**From:** [Kelly Bacon \(CD\)](#)  
**To:** "[lhatchx1@gmail.com](mailto:lhatchx1@gmail.com)"  
**Subject:** VA-21-00004 Hatcher - Transmittal of Comments and RFI  
**Date:** Monday, May 24, 2021 11:19:22 AM  
**Attachments:** [VA-21-00004 Hatcher Transmittal of Comments letter 5-24-21.pdf](#)  
[VA-21-00004 Hatcher - Combined Comments.pdf](#)

HATCHER

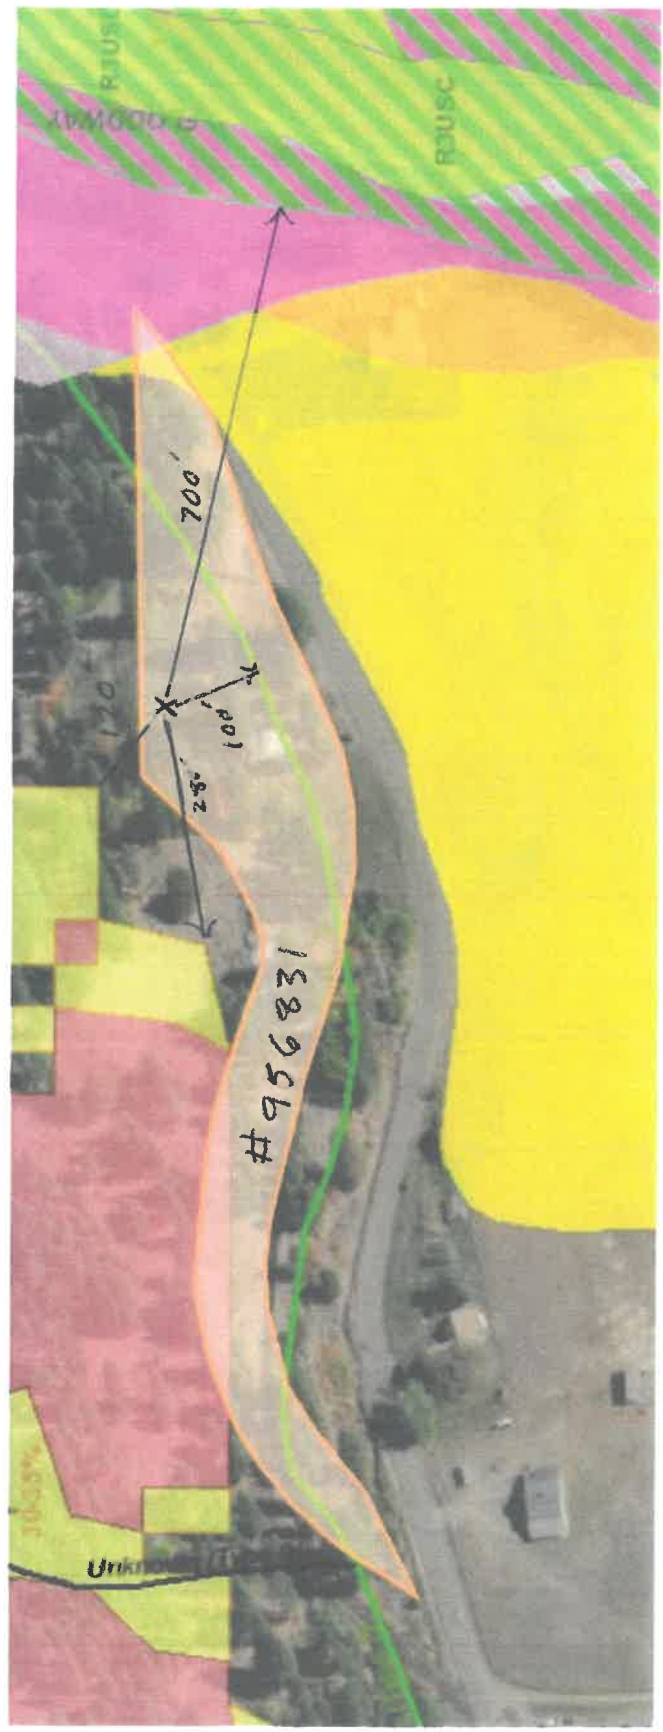
The variance application is asking for a setback of 1 foot from the property line, a 9 ft decrease from the required 10 ft rear setback. There is a 10-foot public utility easement dedicated by the Duke Short Plat located along all property lines. This easement is divided 5 feet on each side of the interior lot lines. Structures are not allowed to be constructed within any easement or Right of Way. Also, the International Building Code requires a minimum of 5 feet setback to the property line for fire protection.

CDS would be unable to approve your variance as requested for a 1 foot setback on the rear property line. Should you choose to adjust your project in order to meet the required minimum setbacks outside the dedicated utility easement and building code setbacks, please submit updated documentation including:

1. An updated site map
2. Updated project narrative
